DAVID EVANS
AND ASSOCIATES INC.

SUBJECT: Ogden Point Short Plat: Comment Response Letter

Thank you for your review of the Ogden point Short Plat. This letter is in response to your revised corrections letter dated August 22, 2019. We have prepared revised documents and included a revised short plat map, site plan, and tree calculations. Staff review comments are listed below in black text, the revised review comment in **red text** and our response to staff comments are provided in **Bold Italics**.

STAMP NOT VALID UNLESS SIGNED AND DATED
 FIRST SUBMITTAL DATE: 2/28/19
 SCALE: HORIZ.: 1"=20' VERT.: -
 PROJECT NO. **LDYB00000002**
 SHEET NO. **1**
 OF **4**

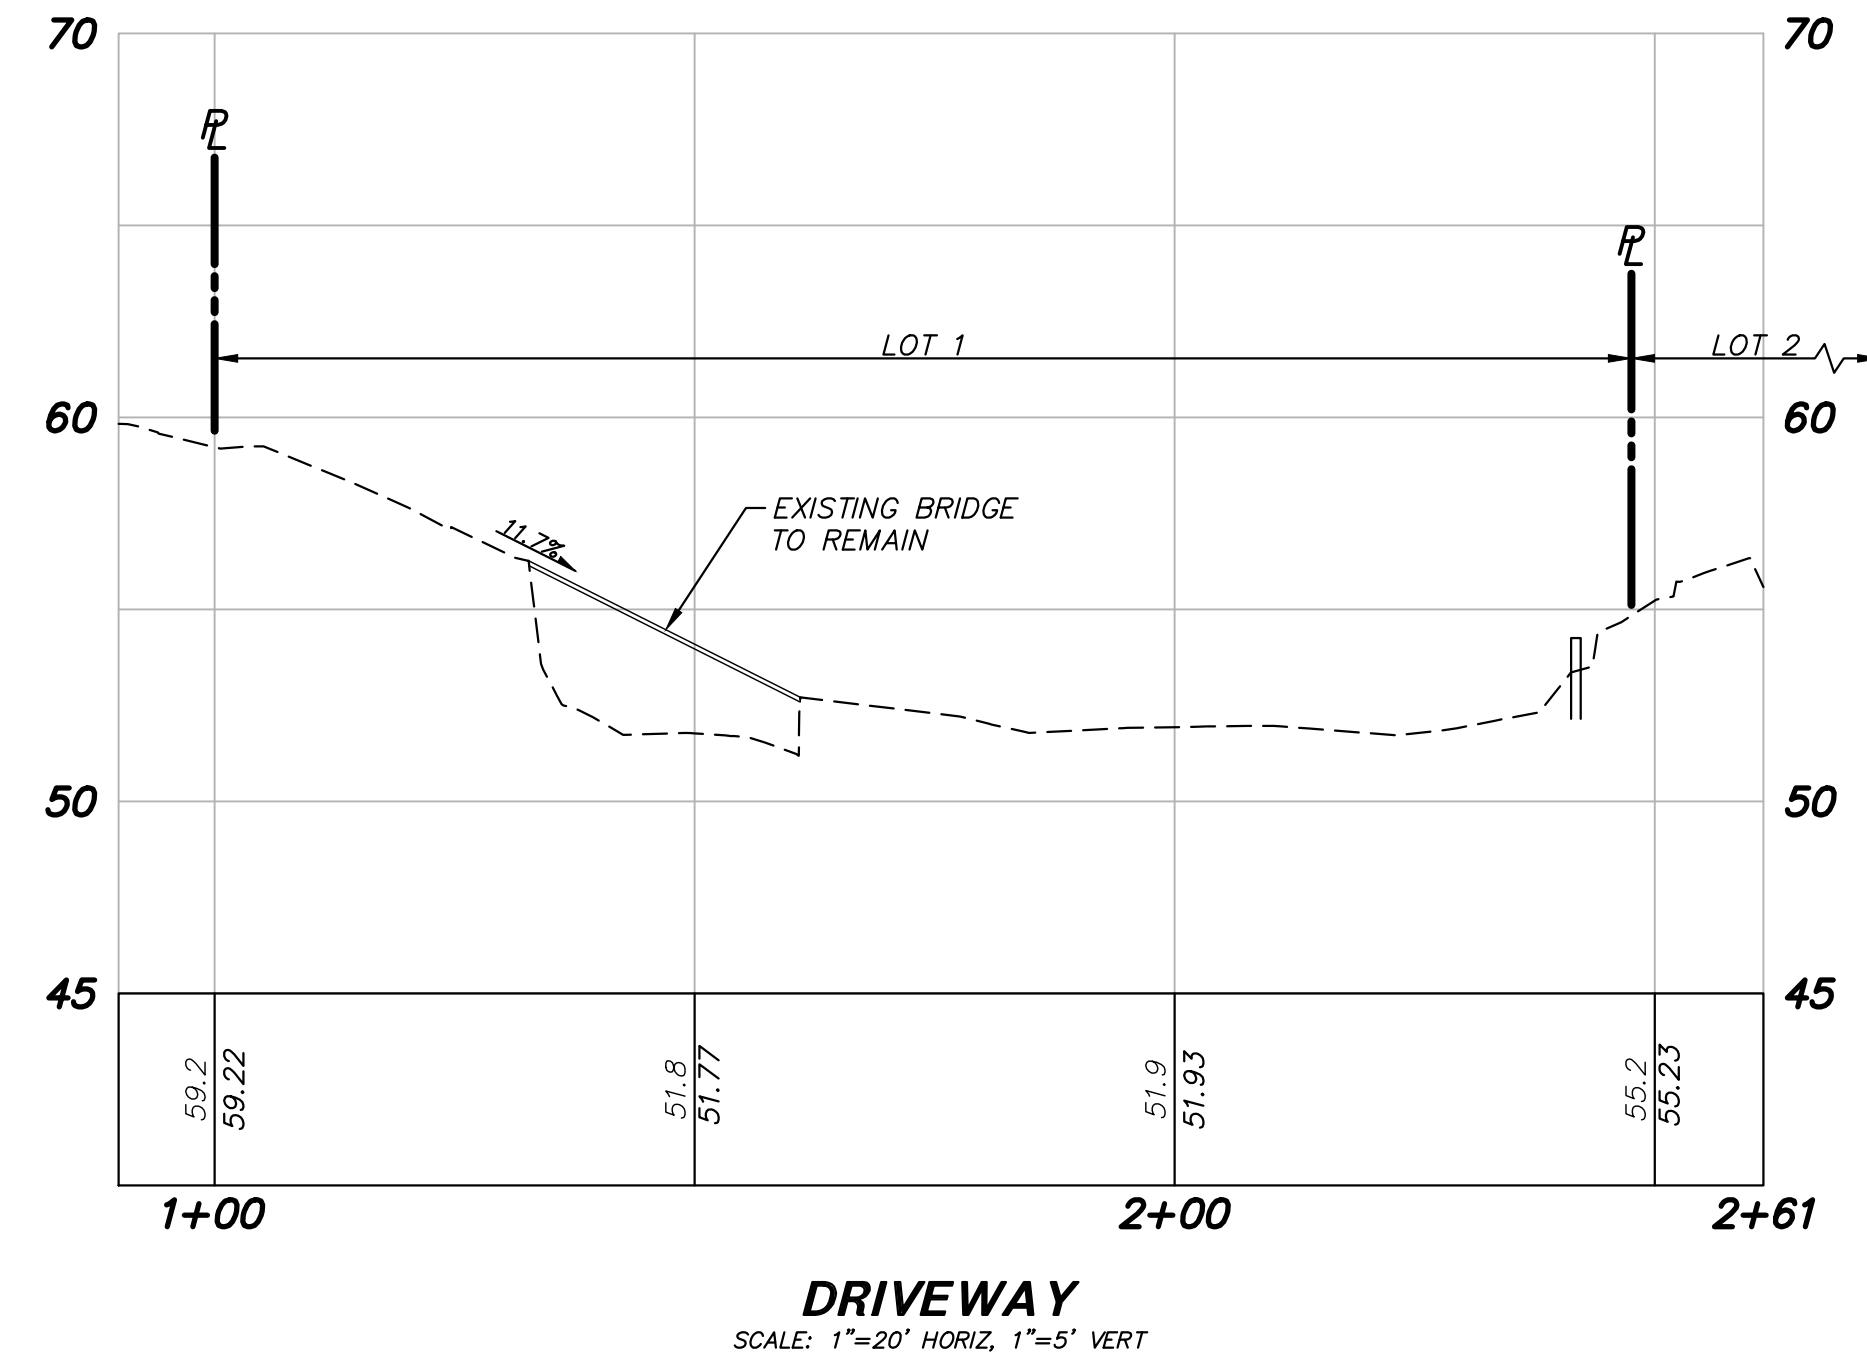
29. Please show the exact locations of the sewer gravity line and the sewer pressure line (it has been field located), then show a revised public sewer easement, 5 feet from the southern sewer line and 5 feet from the northern sewer line. Once the limits of the easement are reviewed, then you will need to provide the legal description for the sewer easement, and the City will provide the easement languages.

The sewer line was potholed and surveyed at the pothole location to verify the location and orientation of the two sewer lines. The additional locate work has confirmed the location of the sewer main shown on the Terrane survey. The Terrane Survey shows the location of the gravity main, while the pressure main follows the same alignment but is offset by one foot to the west (shoreward). These lines are shown on the short plat site plan.

OGDEN POINT SHORT PLAT
DRIVEWAY PROFILE
THE LADYBUG TRUST
OGDEN POINT SHORT PLAT
SHORT PLAT APPLICATION
CITY OF MERCER ISLAND,
WASHINGTON

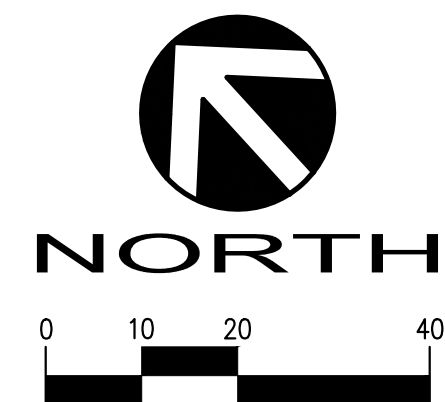
23. Please provide a profile of the entire proposed access road (including onto Lot 2). Please note that the driveway slope can't exceed 20%. ***Discussion occurred in the pre-application meeting about the bridge and that it will be considered during any further application meeting. Requirements could include improving the width, length, and overall weight rating. Code***

Acknowledged.

OGDEN POINT SHORT PLAT CRITICAL AREAS EXHIBIT THE LADYBUG TRUST OGDEN POINT SHORT PLAT SHORT PLAT APPLICATION CITY OF MERCER ISLAND, WASHINGTON

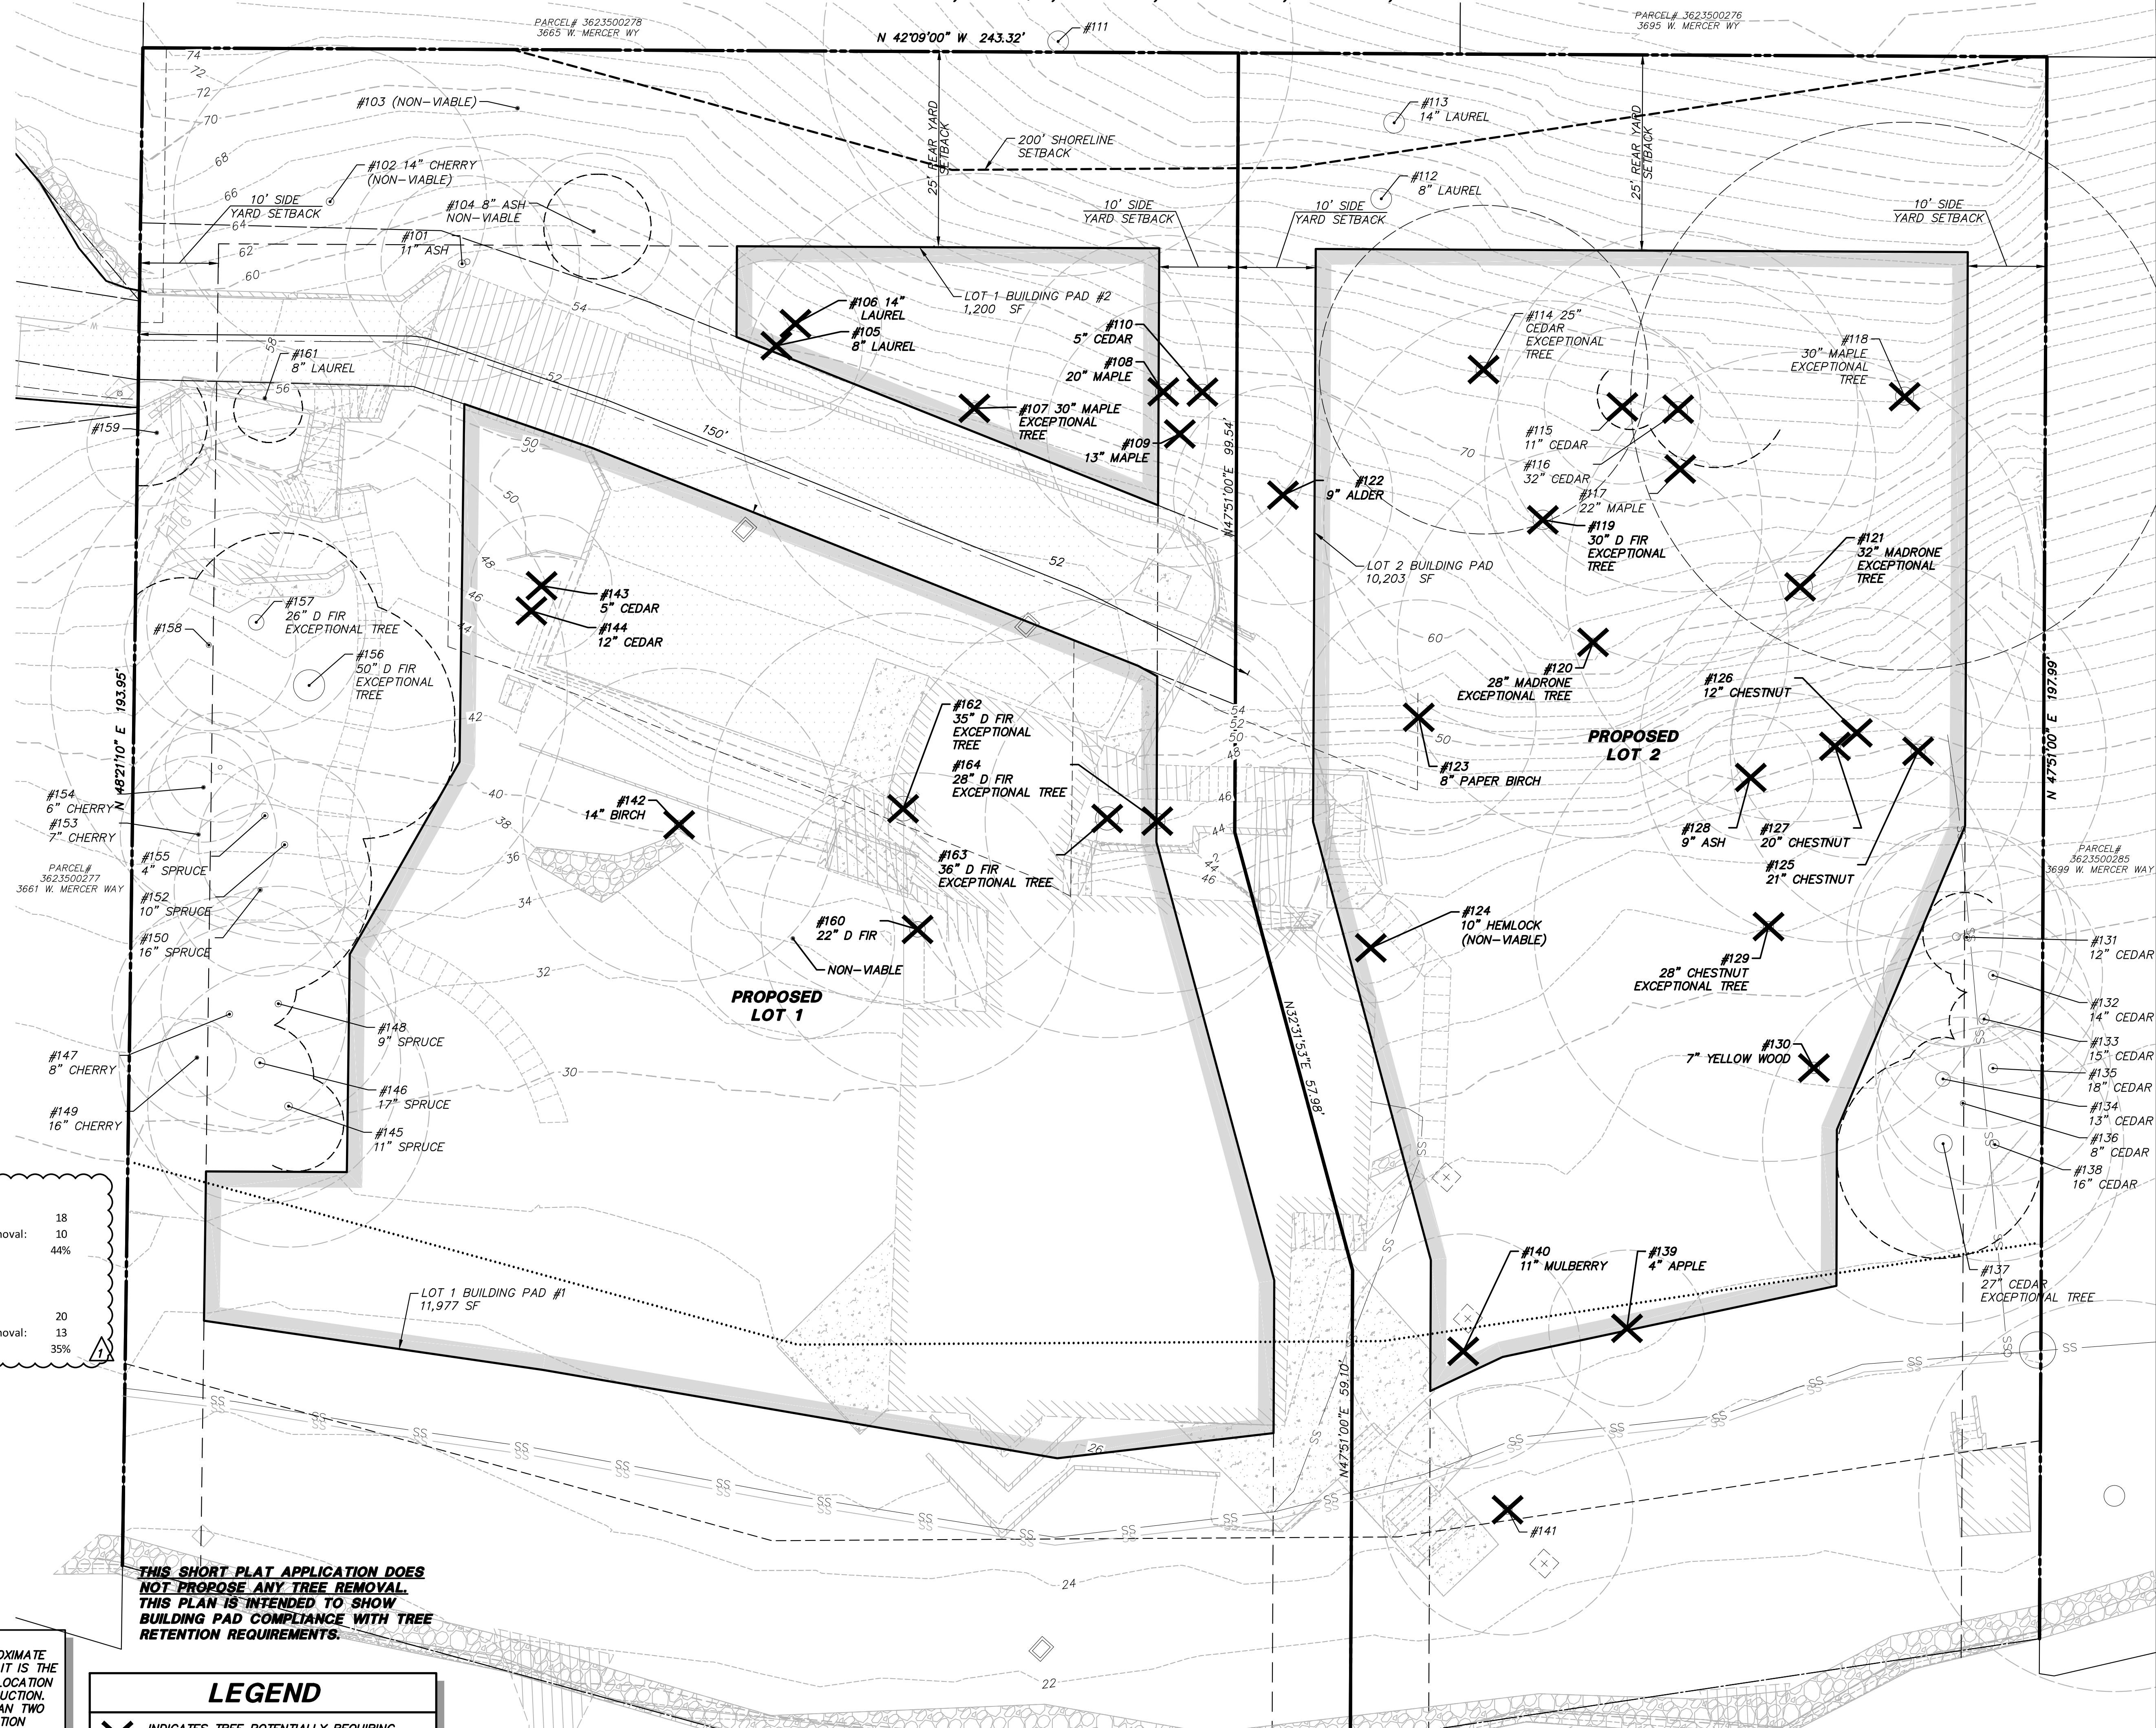
9. Please provide a topographic and boundary survey. The applicant shall provide copies of a topographical map showing the existing land contours using vertical intervals of not more than two feet, completed and signed by a Washington licensed surveyor. For any existing buildings, the map shall show the finished floor elevations of each floor of the building. Critical slopes exceeding 30 percent must be labeled and delineated by a clearly visible hatching. Please keep in mind that the critical slope area is different from the steep slope area, as the City defines steep slope as exceeding 40% slope. **In addition, see comment #29 for additional information required on a survey.**

A topographical survey prepared by Terrane Inc. meeting all of these requirements was submitted with previous submittal and is also included with this resubmittal. This topographical survey work was used as the base map for the short plat document and the short plat site plans. We have added critical slopes of 30% and greater to the short plat map and critical areas site plan. Additionally, the erosion hazard area is now shown on the short plat map. The gravity sewer line shown on the topographical map was field located, exposed and the Terrane Survey was found to be accurate. The proposed sewer easement is now shown on the Short Plat Site Plan.

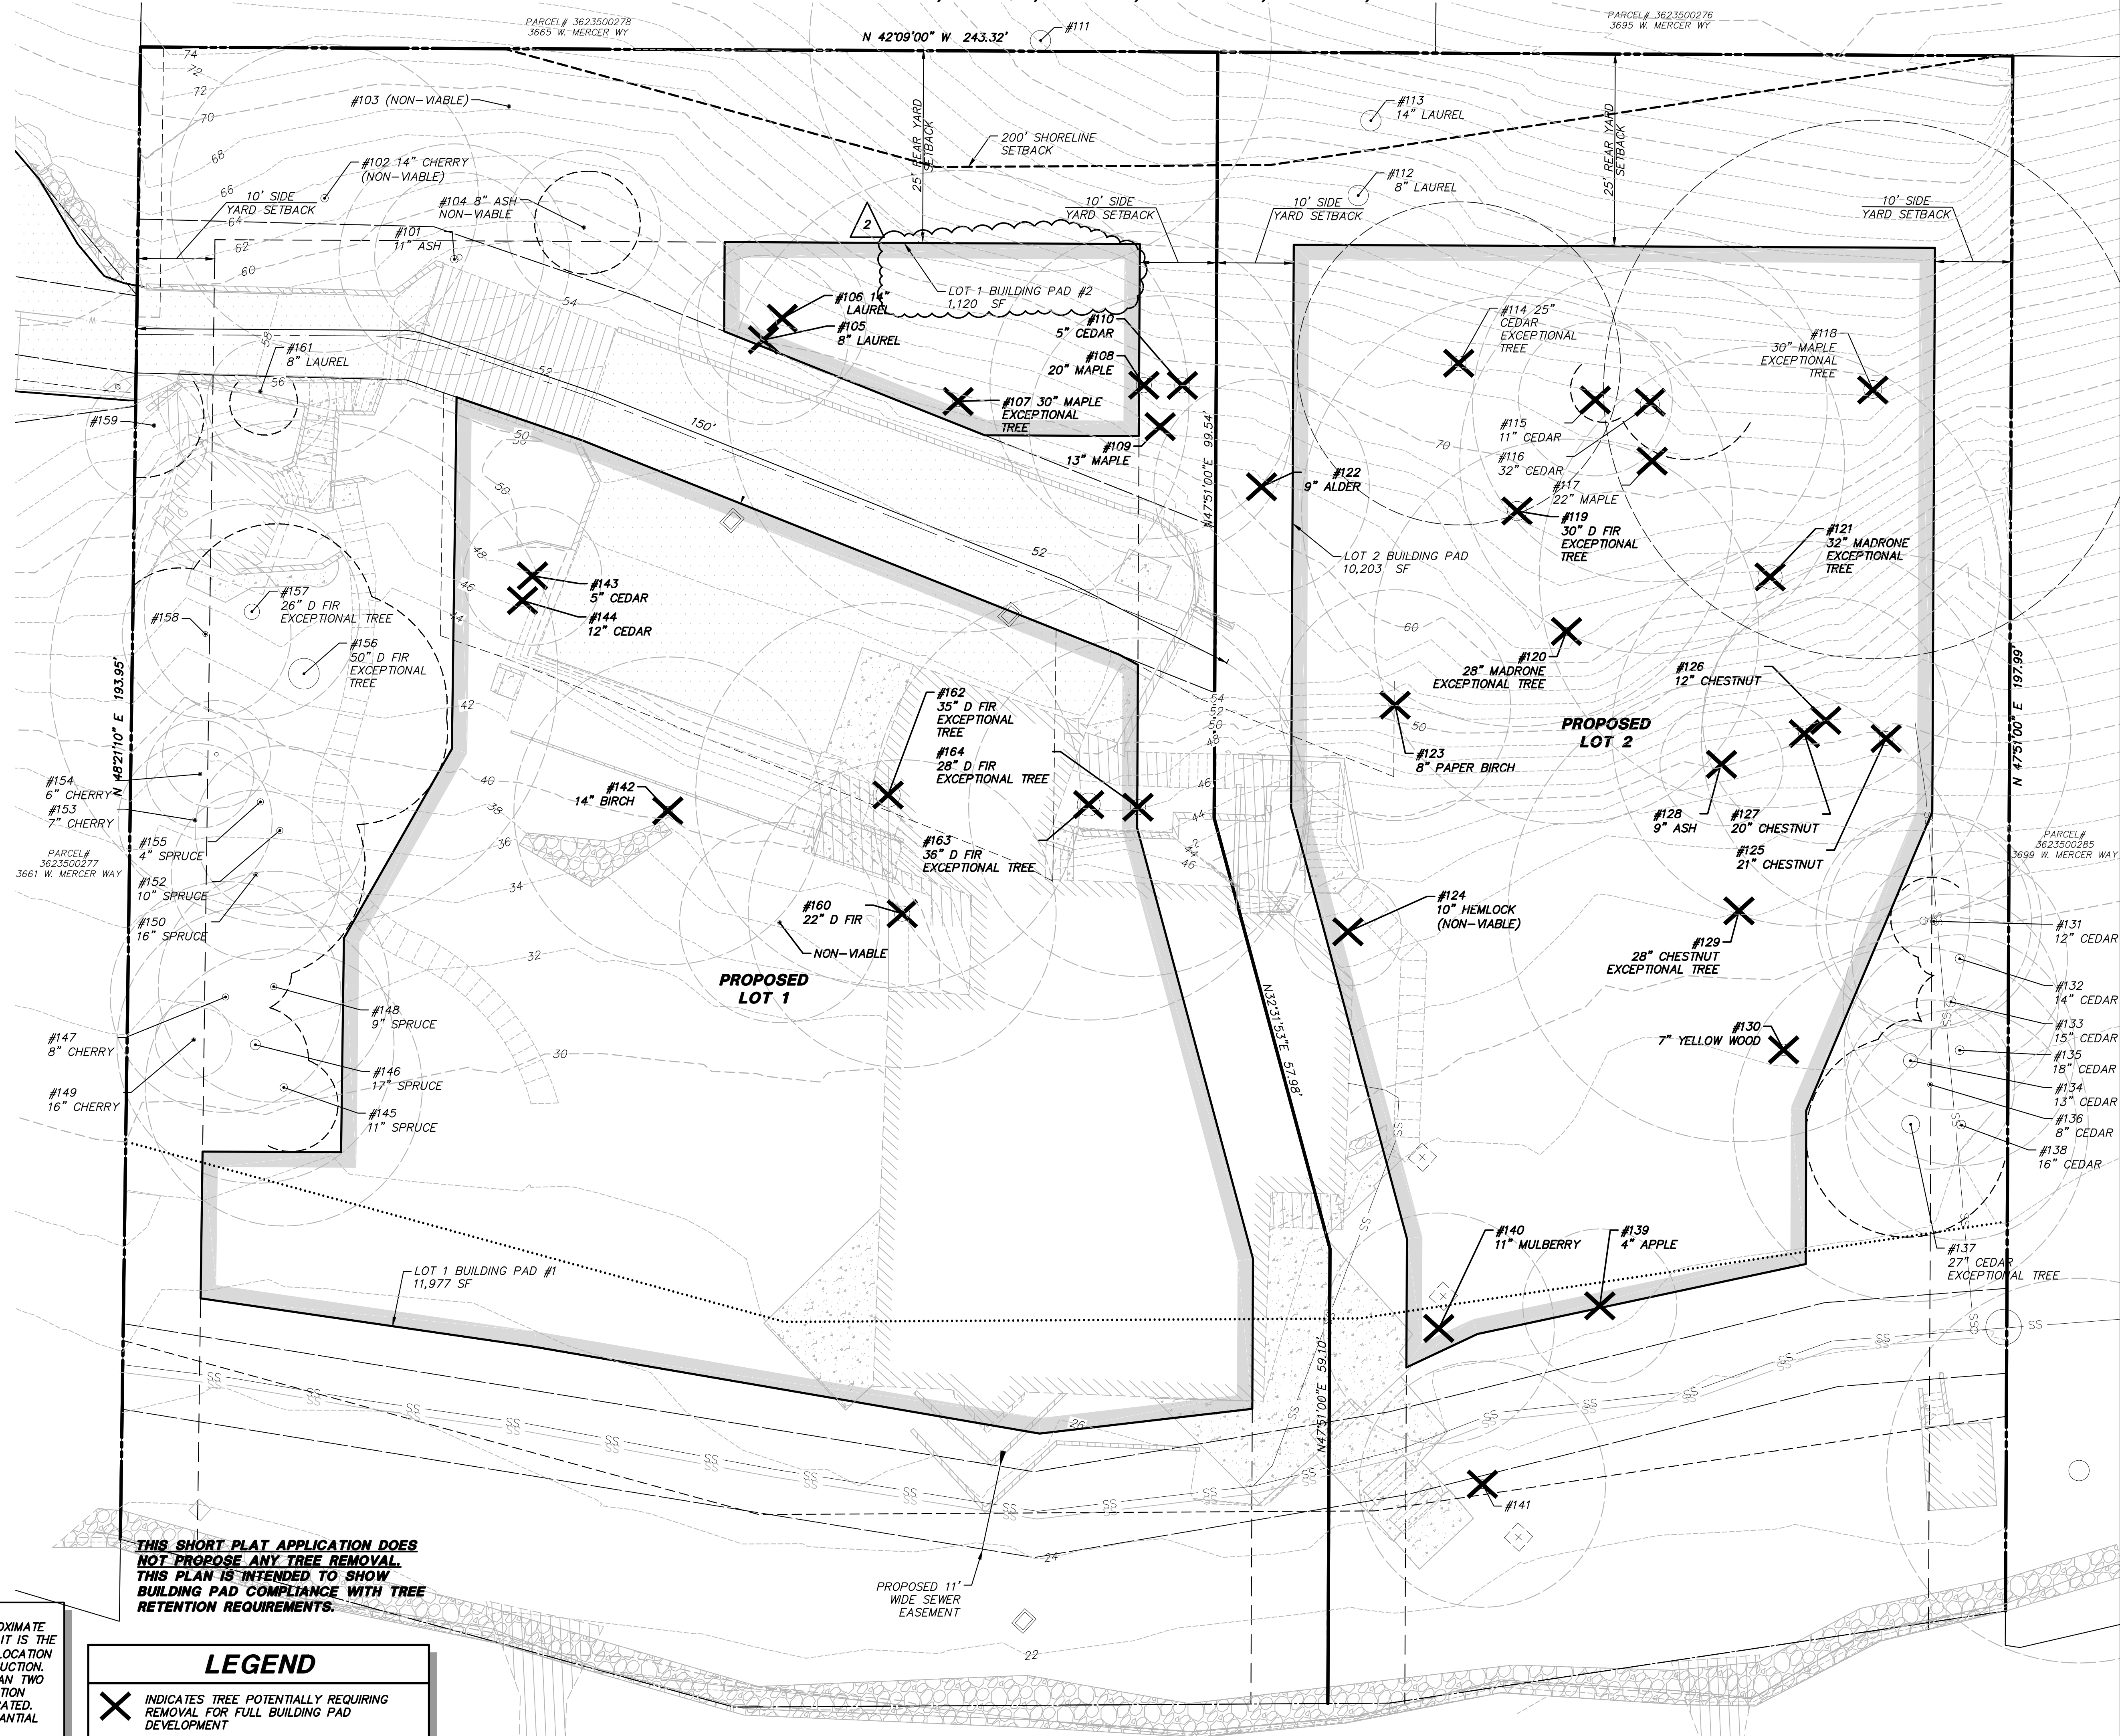
25. Show retained trees with their driplines where protection is required with building pad shown outside these trees' dripline on short plat plans. This plan showing numbered retained trees will be recorded as part of the plat.

26. ***The Preliminary Plat Plans and Critical Areas Determination Plans need to be consistent. The tree plan needs to be included in the SUB19-003 plan set.***

This was shown on sheet 4 "Tree Plan" of the short plat site plan package. We do not agree that the numbered retained trees must be shown on the recorded short plat document. MIMC 19.08 does not specify that trees must be shown on plat documents and we would prefer to not record the trees. We are already showing the building pad area on the short plat plan.

A tree plan was included as sheet 4 of the previous short plat site plan set, this sheet has been slightly revised to identify significant trees per MICC 19.10.
